Our ref: Hunter Indoor Sports Centre (HISC) (SSD-65595459)

Subject: Request for Additional Information

I refer to the amended State Significant development application for Hunter Indoor Sports Centre (HISC) (SSD-65595459) and the Department's Response to Submissions (RtS) letter dated 26 September 2025.

NEWCASTLE BASKETBALL STADIUM : PROPOSED SITE PLAN

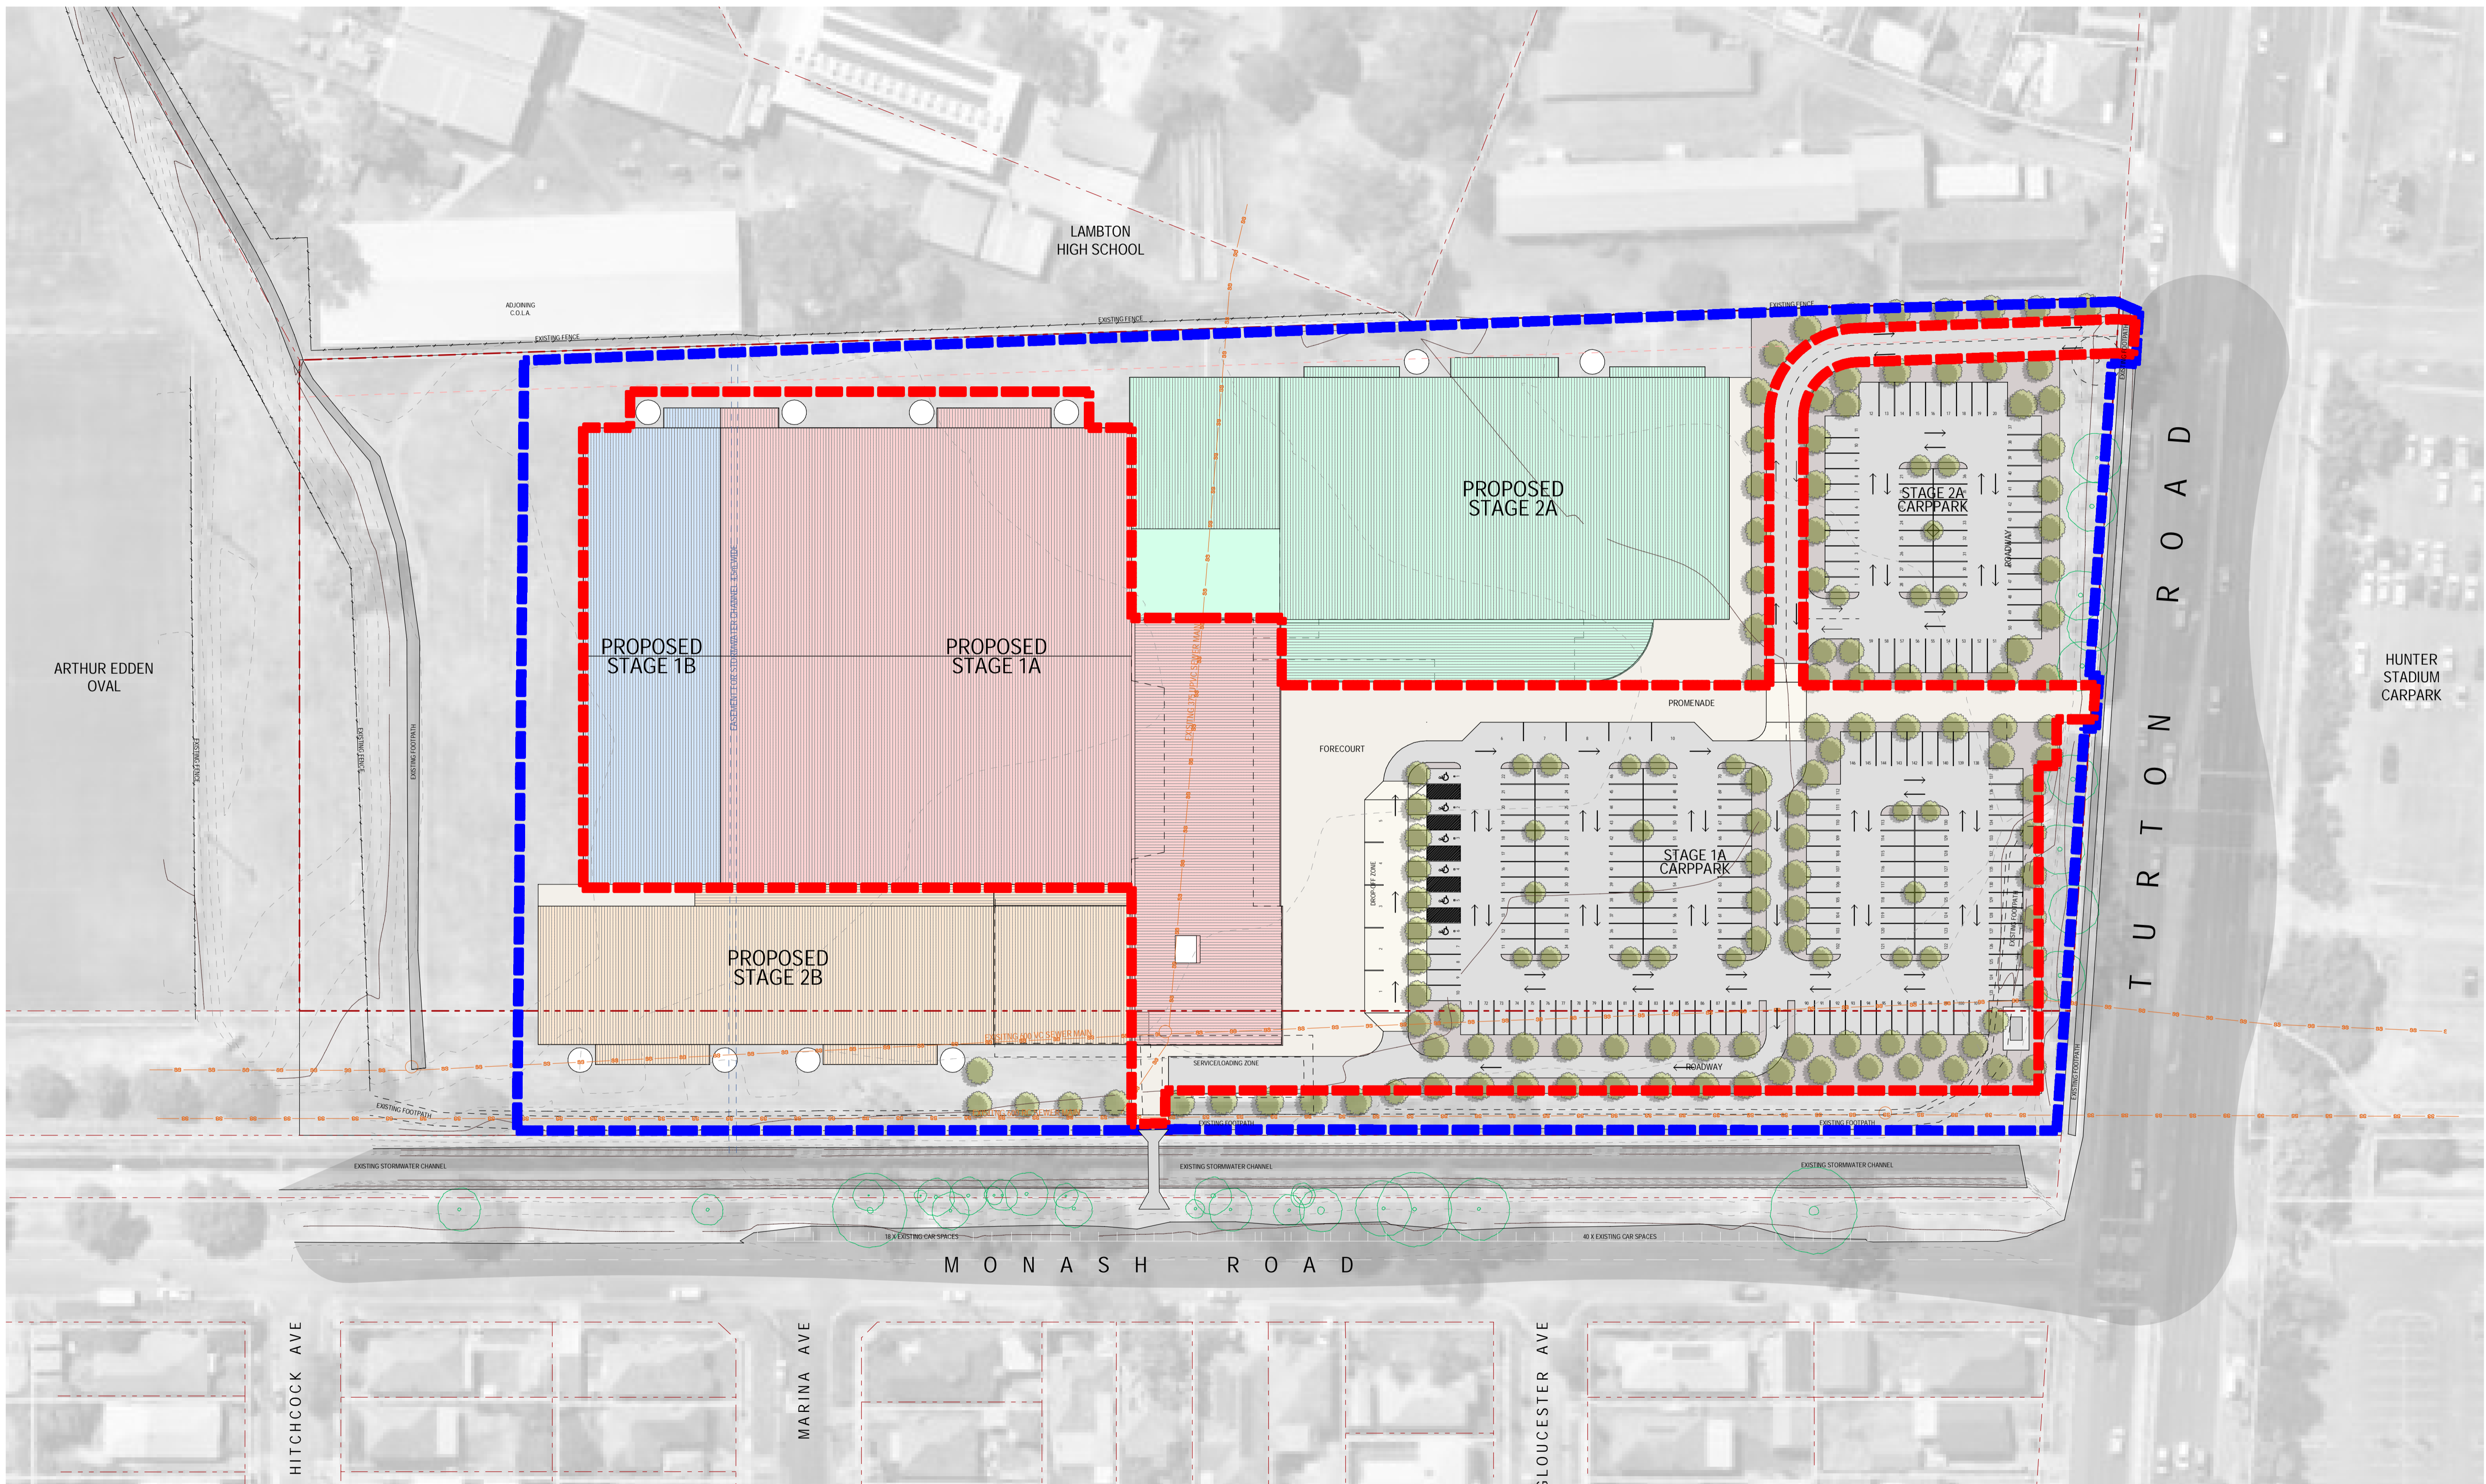
- f) Identify on plan, the location of parking for 22 seat coaster buses as referred to in the TIA.
- g) The swept paths for a 14.5m bus require traversing multiple lanes on Turton Road when entering and exiting the site. What is the impact on traffic queuing and safety both in the car park and on Turton Road? It is also noted such buses result in potential vehicle conflict within the car park itself. It is recommended the layout be revised to address this concern.

- c) The building remains internalised with limited passive surveillance or public facing uses along the Monash Road frontage. Provide further meaningful activation and permeability along this edge of the site.
- d) The northern and western facades remain inactive and present as 'back of house' to surrounding development. Further refinement is required to reduce visual bulk and improve the interface to the school and residential properties.
- e) The amended application does not respond in full to the matters raised by the State Design Review Panel on 1 March 2024. There remains opportunity to optimise green space, amenity and permeability (SDRP Item 10) and respond meaningfully to SDRP Items 17 and 18 by maximising the use of rooftop solar to support the facility's energy needs incorporating low-carbon, sustainable materials, and aligning the project with NSW's Net Zero Plan.
